Planning Application 8 Flint House

Reference: R/141/15/PL – 8 Flint House

Drawing No:	15/05/2015	Date:	15th MAY 2015
Description:	BALCONY BALUSTRADE	Finish:	GALVANISED, PPC.
Project:	MR MARTIN

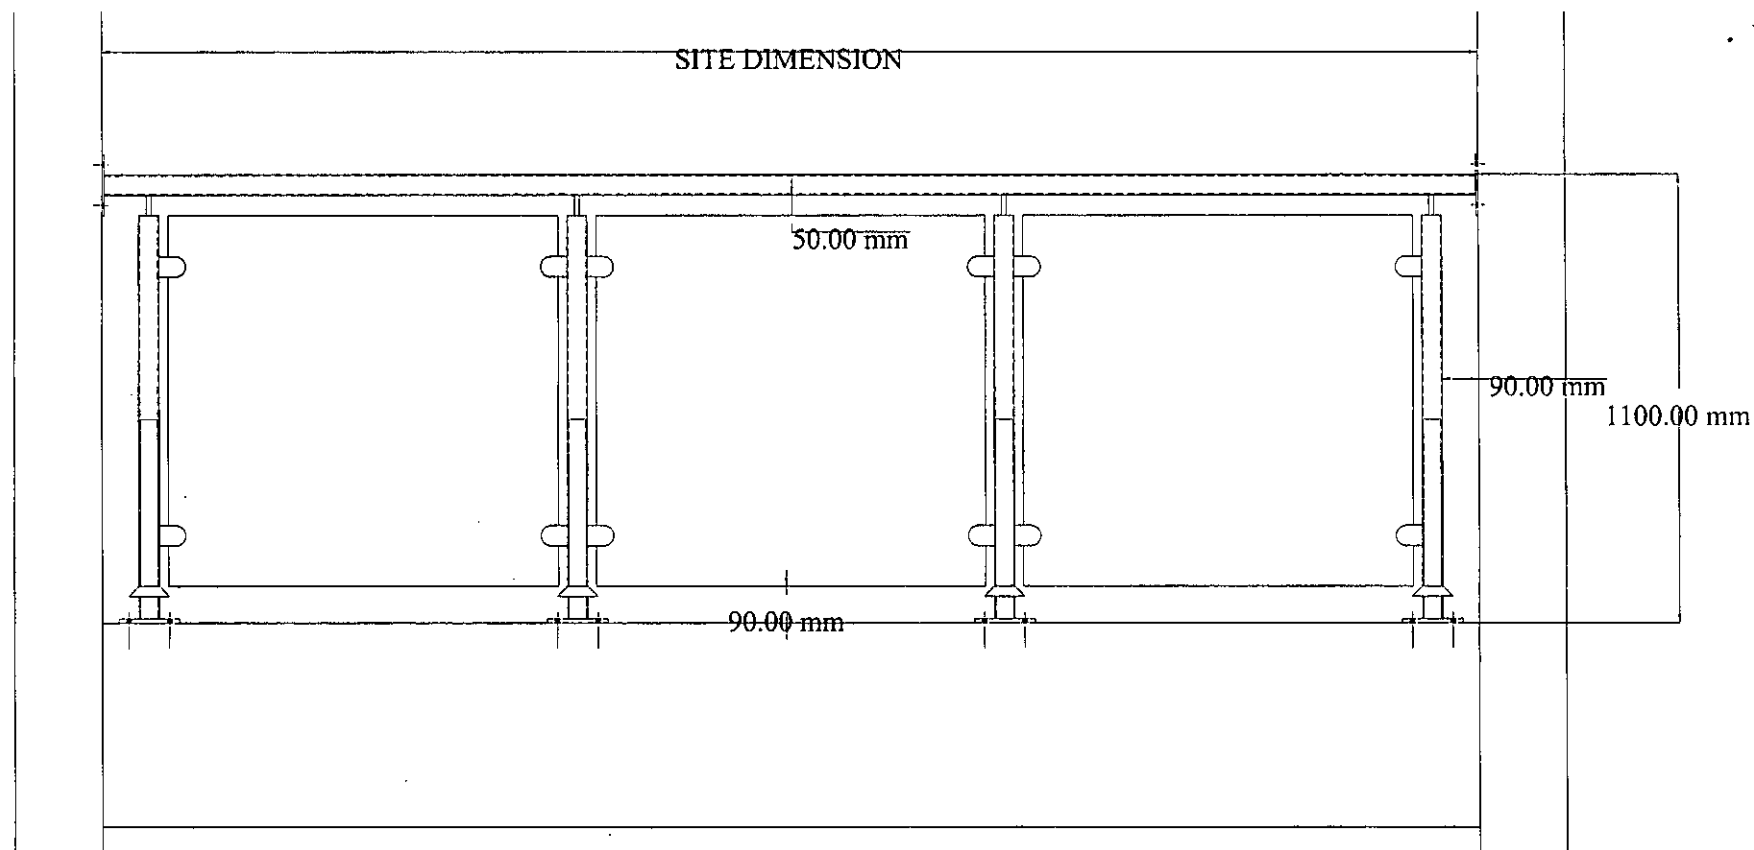
- We are a community of 39 flats and dwellings, and we feel such a radical change to the fabric of Cudlow Garden would be wholly out of place. The flats are basically similar with patios or balconies, though there are individual quirks, but a structure of glass and steel would be detrimental to the overall look and vintage character of Cudlow Garden.

- Finally we would also mention that this application is for replacement panels. There are no panels at the moment – it is a balcony surrounded by railings, therefore the request is for a complete and fundamental change, which the Directors deem to be totally unsuitable.

This notice is a bit misleading as "existing balcony panels" are in fact "existing balcony railings" which are painted white. If these are maintained regularly with the correct paint, there are no problems. Therefore, I am opposed to this planning application because to change to glass panels with steel uprights would completely change the appearance of one balcony to such an extent that it would stick out like a sore thumb!

- 1) Glass would be too hot for the depth of balcony.
- 2) Flats are not modern so I think glass would look out of place.
- 3) Galvanised steel with the new required spacing would be a better alternative if made similar to the existing.
- 4) Duty of care I am not aware of any incidents or accidents in the last 52 years.

The replacement should be like for like as near as possible with railings retained rather than the introduction of glass panels.

Modern glass panels will not fit the character of these buildings designed and erected as they were some 60 years ago.

Random introduction of glass panels on one balcony will have a huge detrimental effect on the appearance of the block concerned and indeed on the whole estate.
